From: Sue Howell
Sent: 19 November 2018 16:25
To: Planning.Responses
Cc: David Easton
Subject: RE: Planning Consultation on: BE/77/18/PL

Comment from Greenspace

Registered: 9th August
2018
Site Address: Land West of New Barn Lane Bersted
Grid Reference: 491571 101058

Description of Works: Erection of 10 No. dwellings & associated works.

client: Linden Homes
drawing: Landscape Proposals
date: June 2018
scale: 1:200@A1
drawing no: LIN21257 12DR
drawn: DC checked: AE

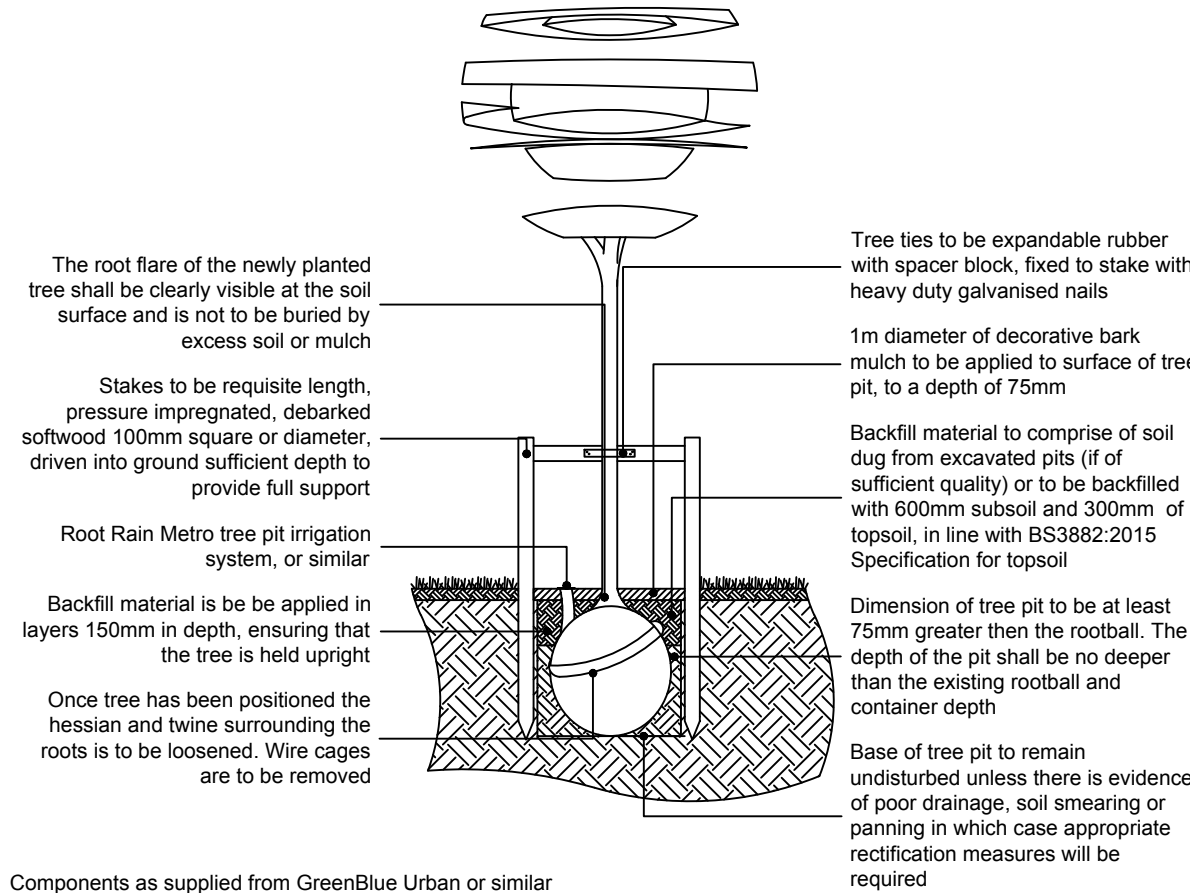
I would reiterate these comments and reinforce the need for the green areas associated with this application BE/77/18/PL to be of a high quality design and implementation. I have already raised my concern over the size and location of the SuDS feature within the POS and the proximity of this to play. The POS does not appear to have been diminished further in quantity to that originally masterplanned, simply the units re-planned to accommodate these additional 10no plots.
